Application for a non-material amendment following a grant of planning permission.

erection of two story extension to rear

1021/62/92105/w

Proposed Rear Elevation

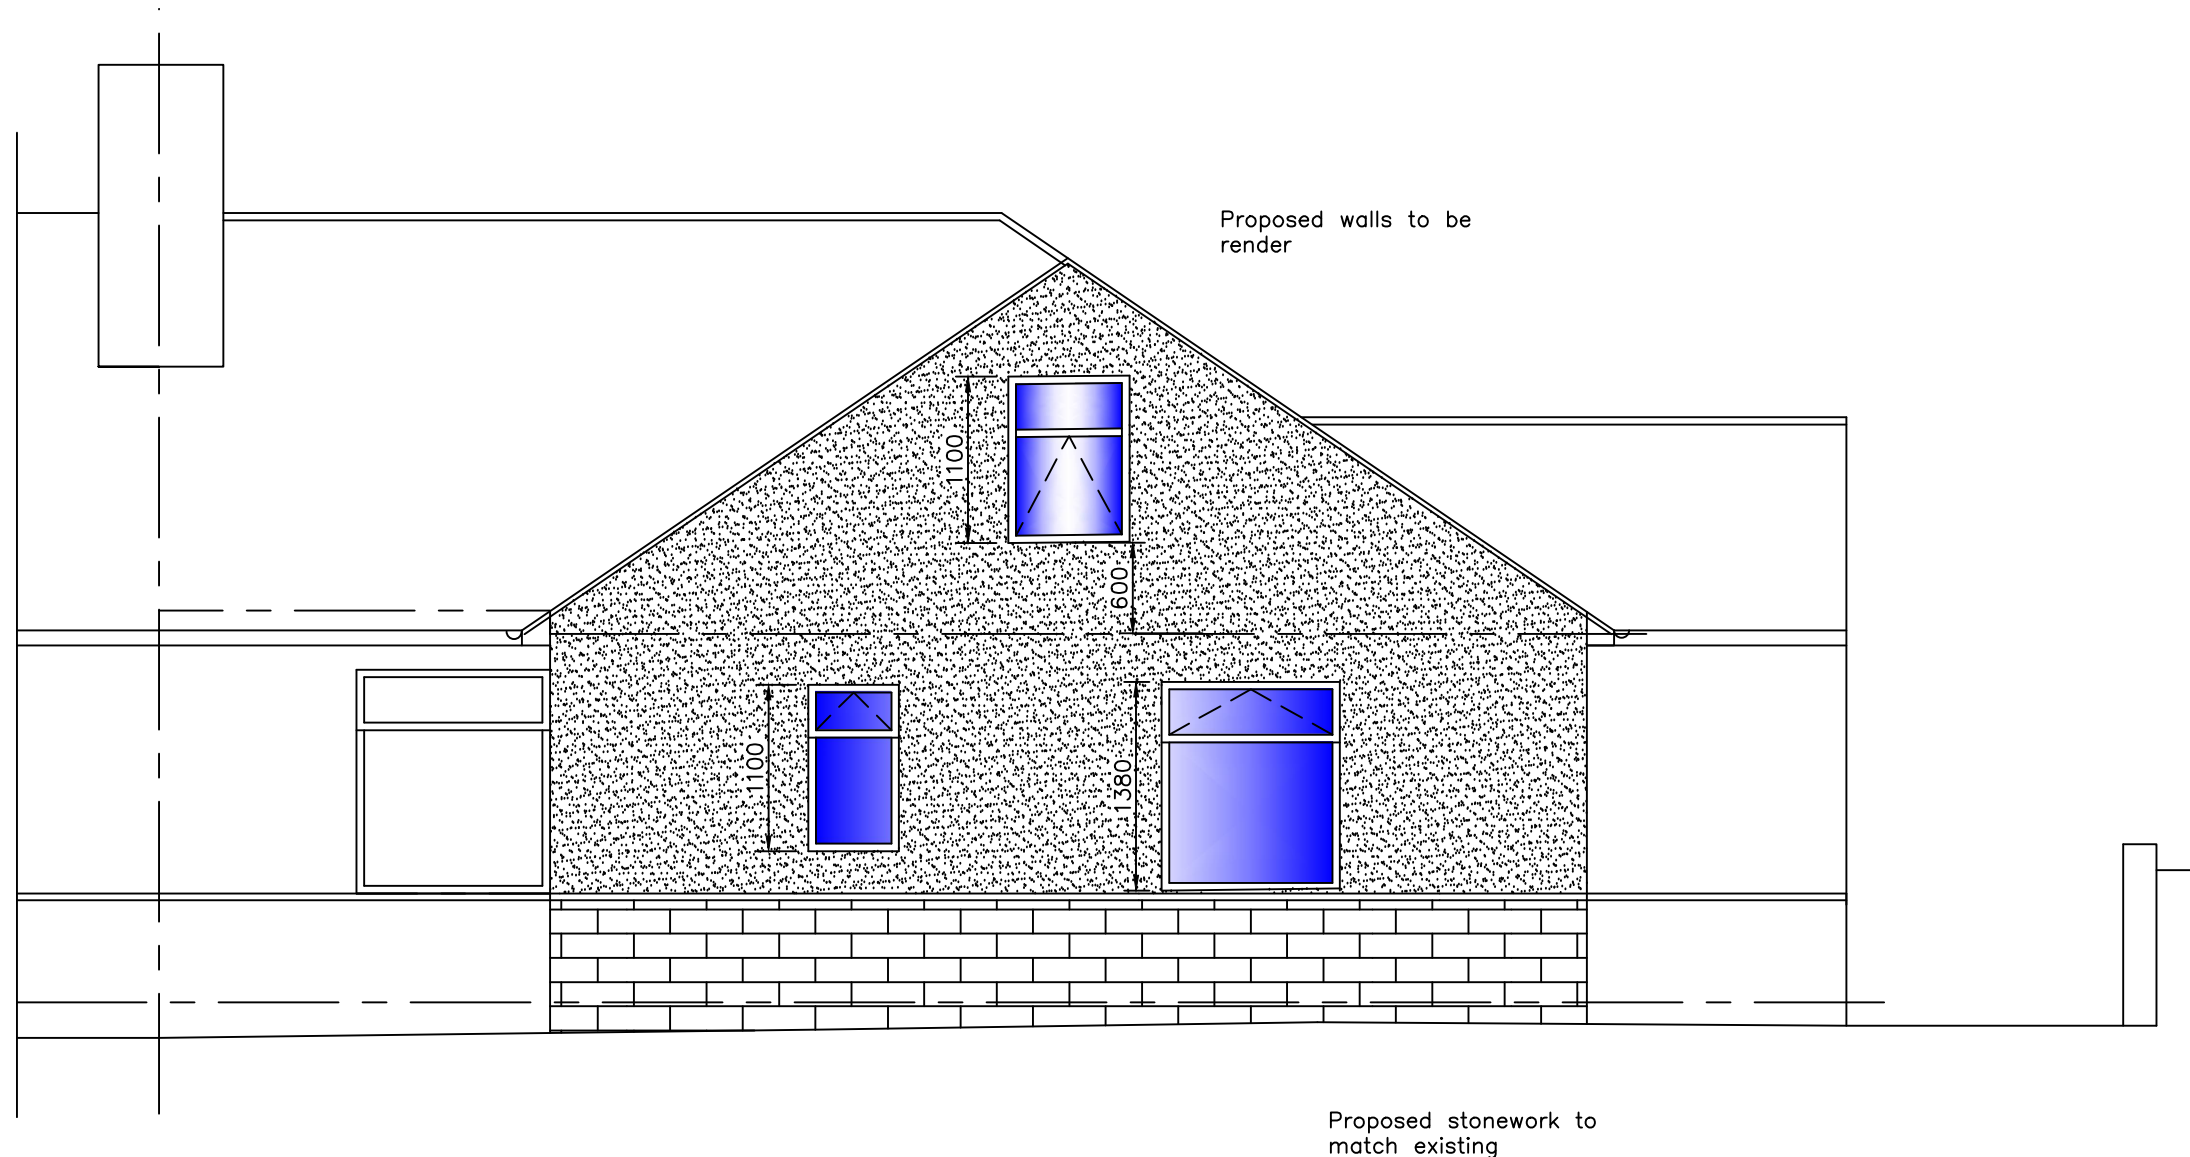
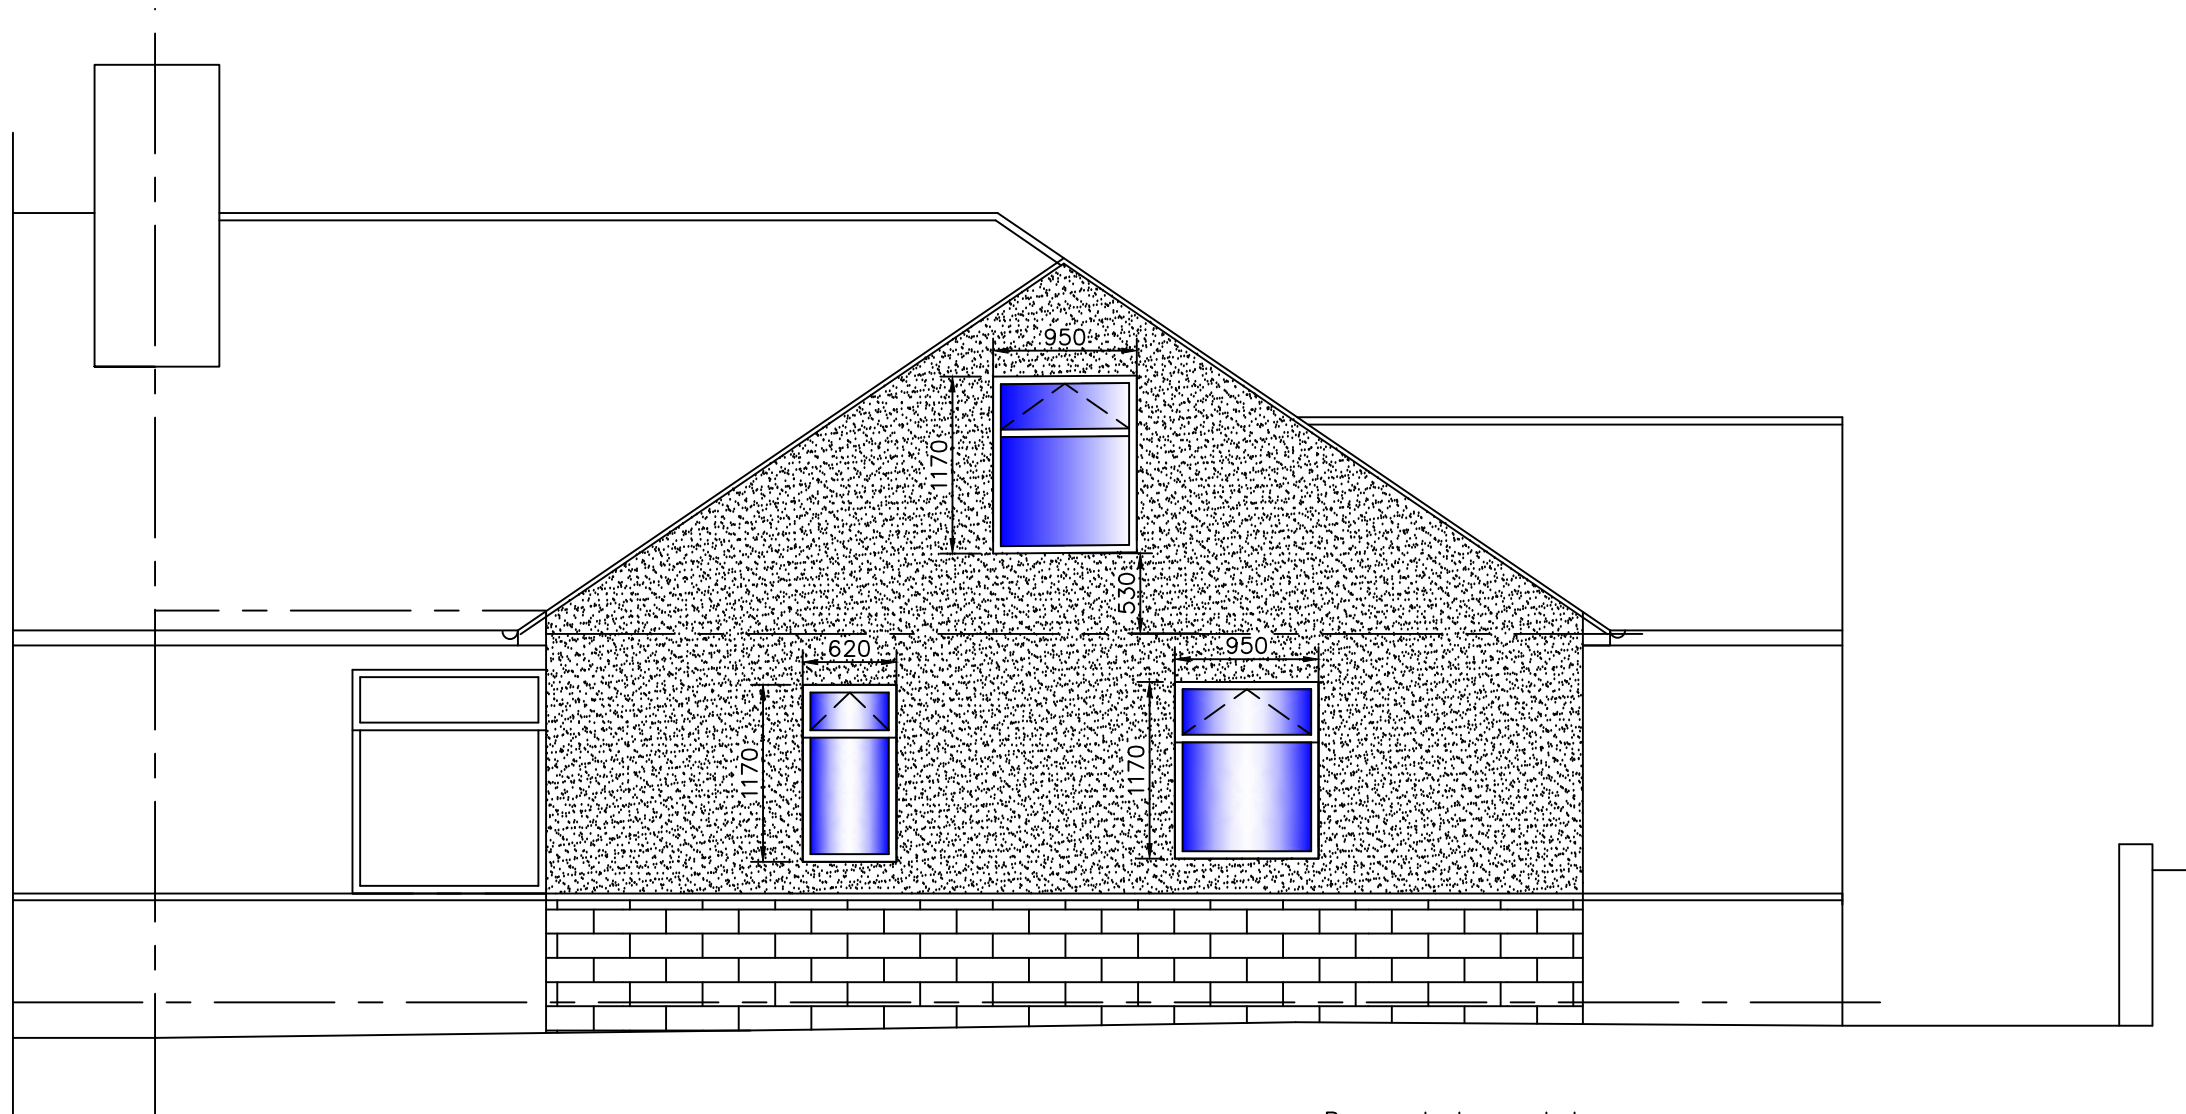
changing e all thnee the window sizes in the rear elevation to 1170 mm in height rather than 2 windows being 1100mm and the other being 1380mm

i would like to ammend the sizes because i have existing windows that size on site and also the 1380mm high window would would look out below the existing ground level which isnt very practical
